CITY OF ALBUQUERQUE

Re: Universe Street Capacity Analysis ~~X~~
Engineer's Stamp Date 2/14/13 (C09/D001B)

TO:	Curtis Cherne, PE, City Hydrologist
FROM:	J. Graeme Means, PE
CC:	Martin Eckert, APS Real Estate Director, Annelle Darby, APS Staff Architect Jeff Mortensen, HMCG Principal Engineer
DATE:	02/26/2013
PROJECT:	APS Volcano Vista High School – City Hydrology File C7/D9
RE:	Summary Analysis of Connection to Proposed Storm Drain in Universe Blvd. NW
JOB NO:	HMCG 2012.182.9

Re: Universe Storm Drain – City Project # 761283

B ORIFICE PLATE DETAIL
NOT TO SCALE

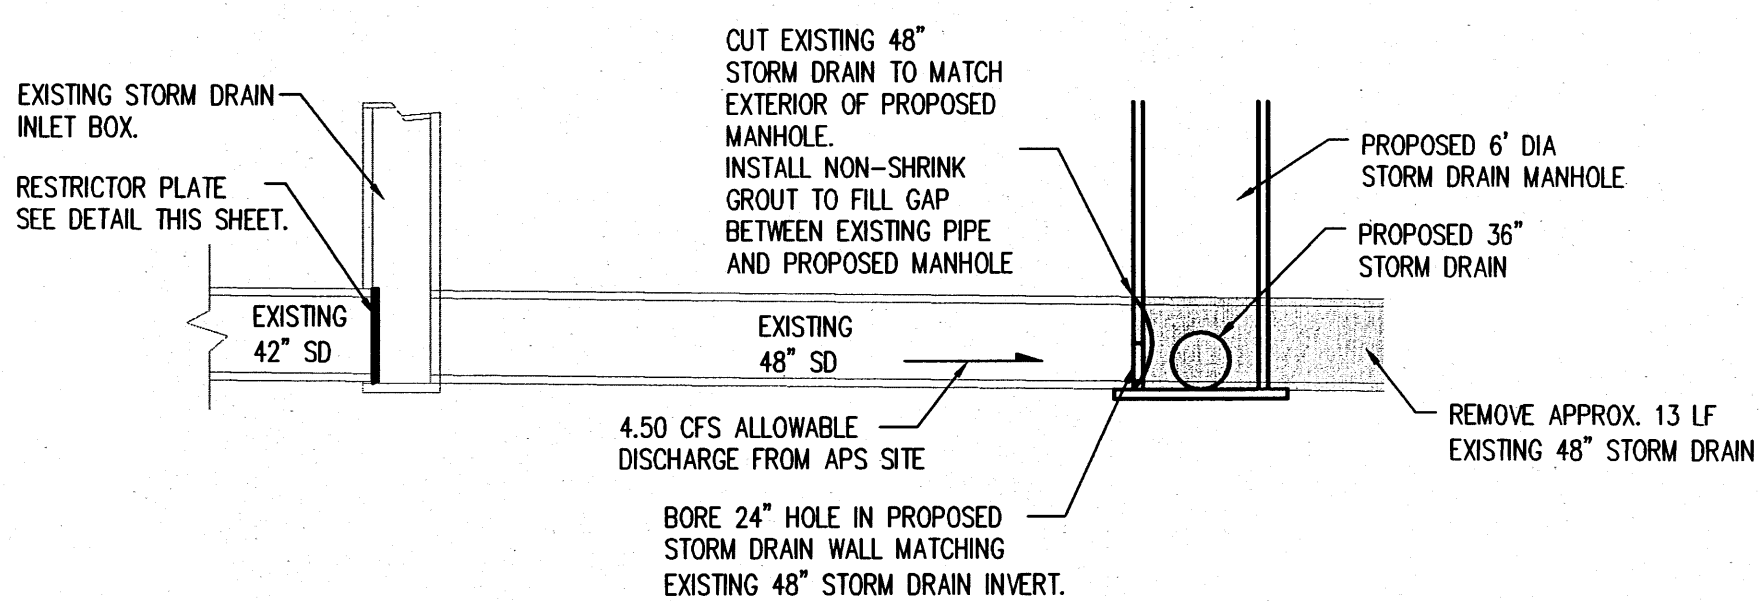
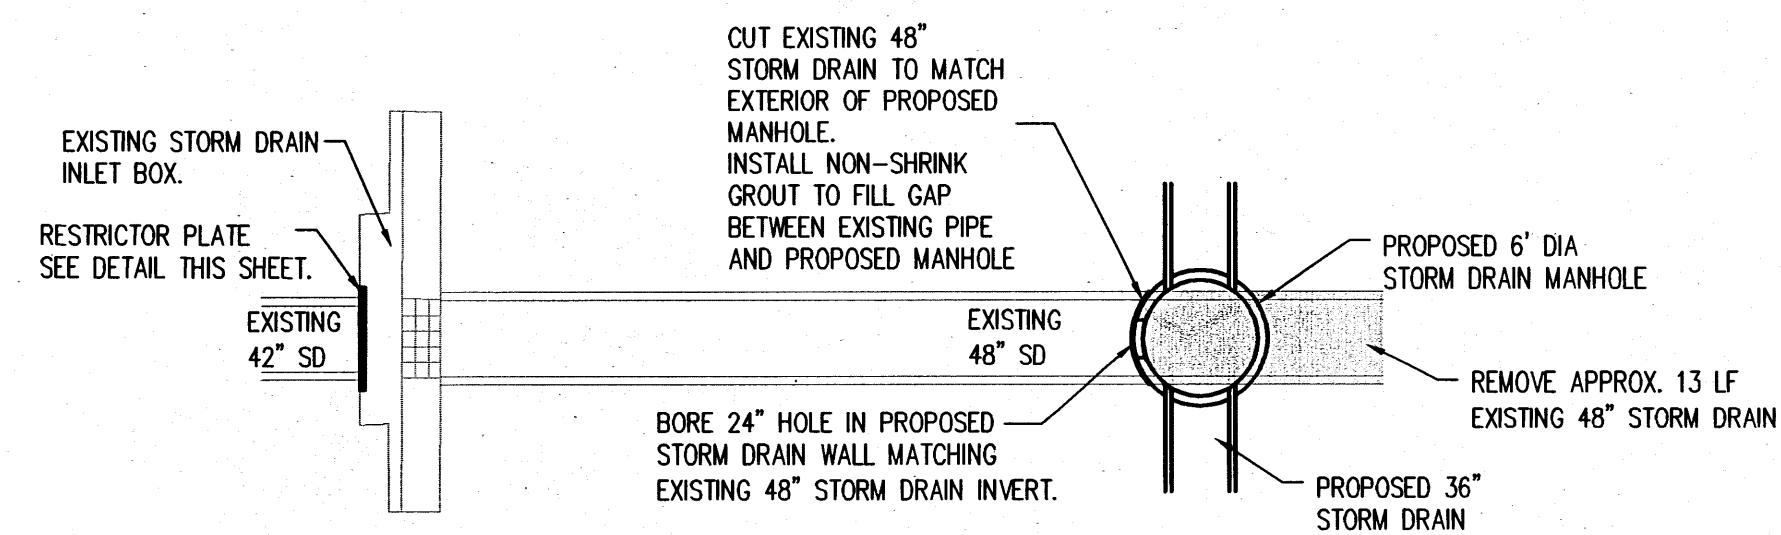
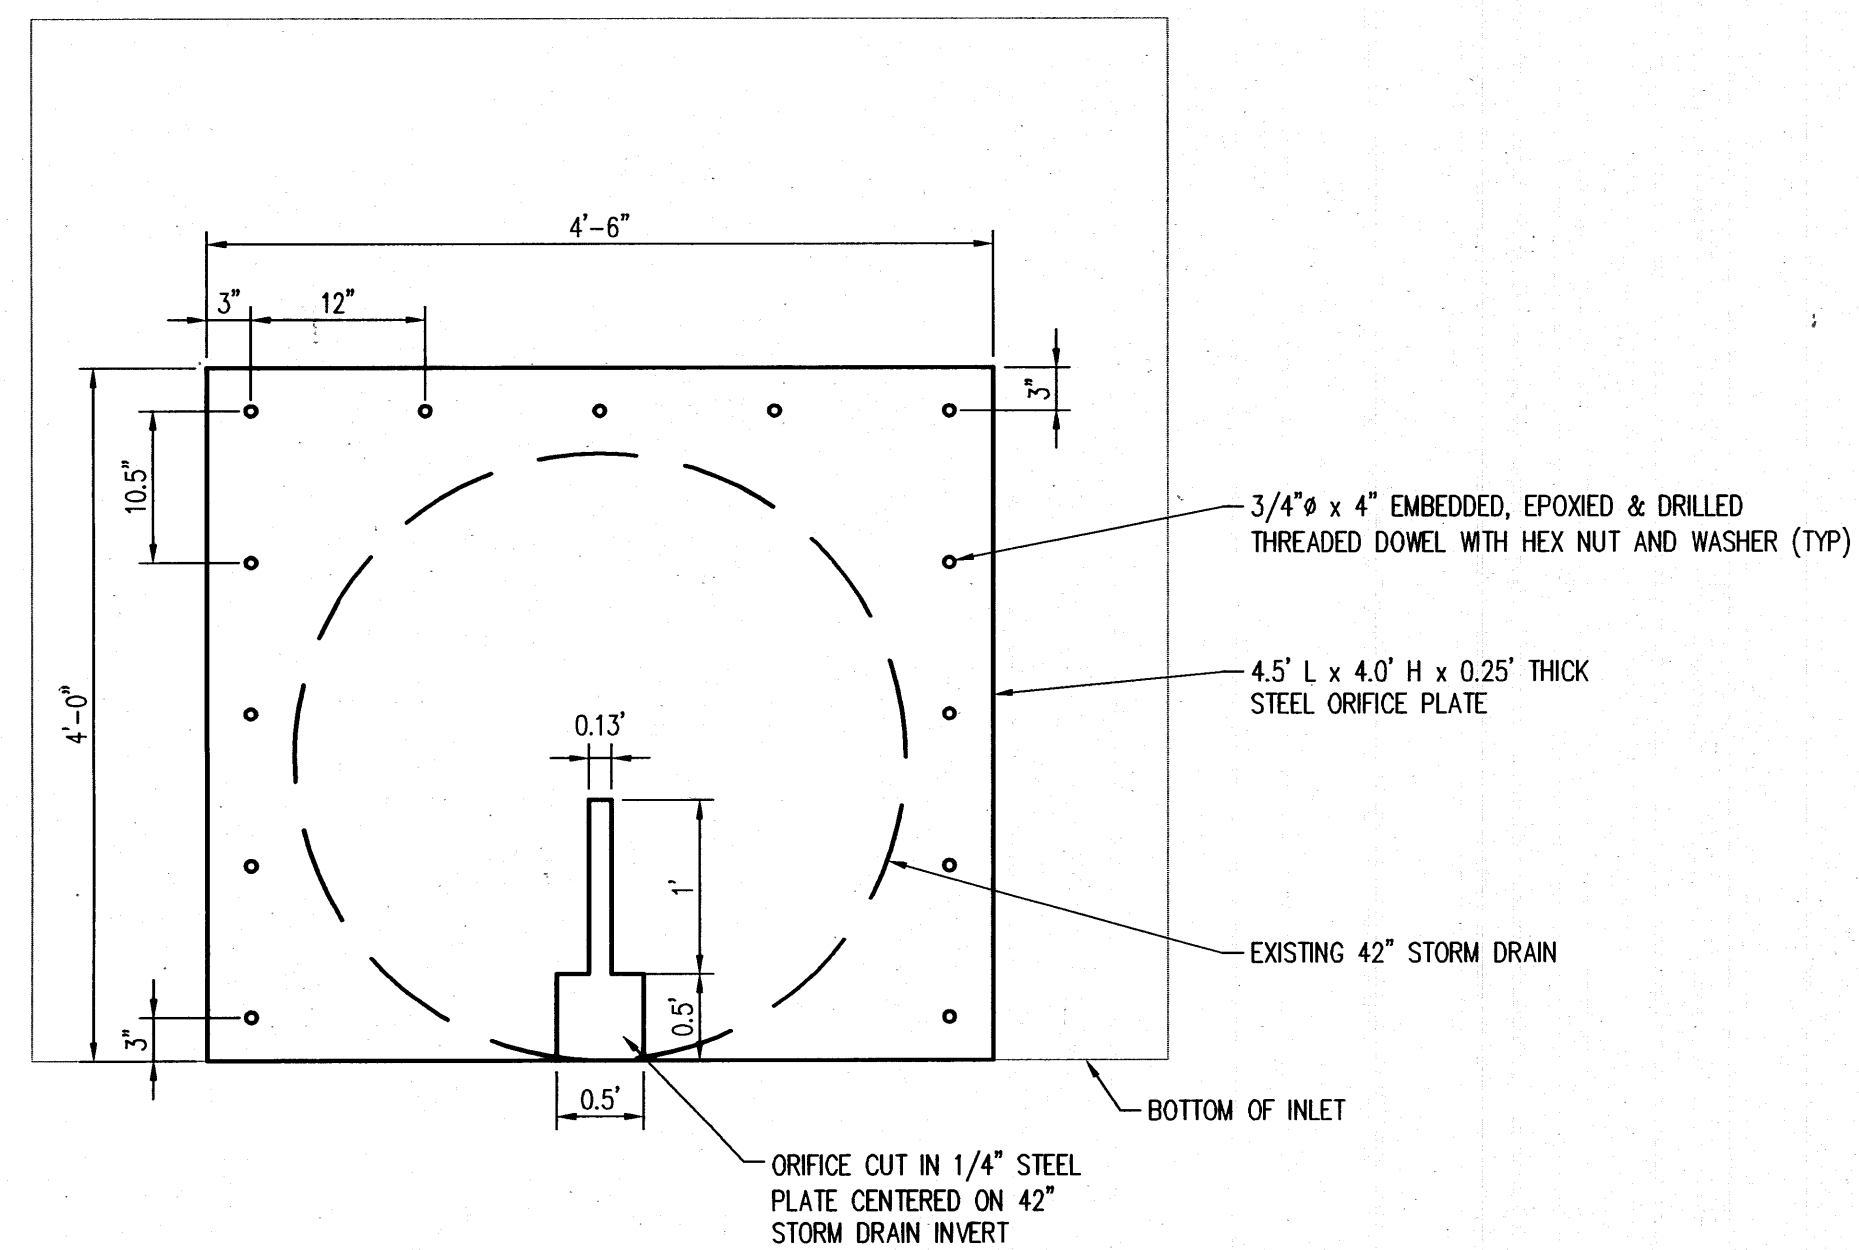
As identified during our meeting, the proposed construction plans recently submitted to the City for approval of a public storm drain in Universe identify a 36 inch pipe at this location and do not provide any connection to the existing 48 inch lateral. Instead, the plans propose to trim the lateral back as it conflicts with the proposed storm drain.

Based on the following, we have determined that it would be feasible to construct an 18 inch connection (sleeved within the existing 48 inch lateral) between the existing inlet and the proposed storm drain with an orifice plate in the back of the inlet or in the upstream private APS storm drain:

Graeme,
Shahab and I have reviewed this draft and offer the following:
The Q allowable for the APS site equals Q (pressure flow in lateral) minus Q (inlet)

The Q Allowable for the APS site is 26.2 cfs.
The orifice plate would need to be installed upstream (private side) of the inlet in Universe Blvd.

Graeme,
 Shahab and I have reviewed this draft and offer the following:
 The Q allowable for the APS site equals Q (pressure flow in lateral) minus Q (inlet)

The Q Allowable for the APS site is 26.2 cfs.
 The orifice plate would need to be installed upstream (private side) of the inlet in Universe Blvd.

4' rolls to build orifice plate in back
of inlet.
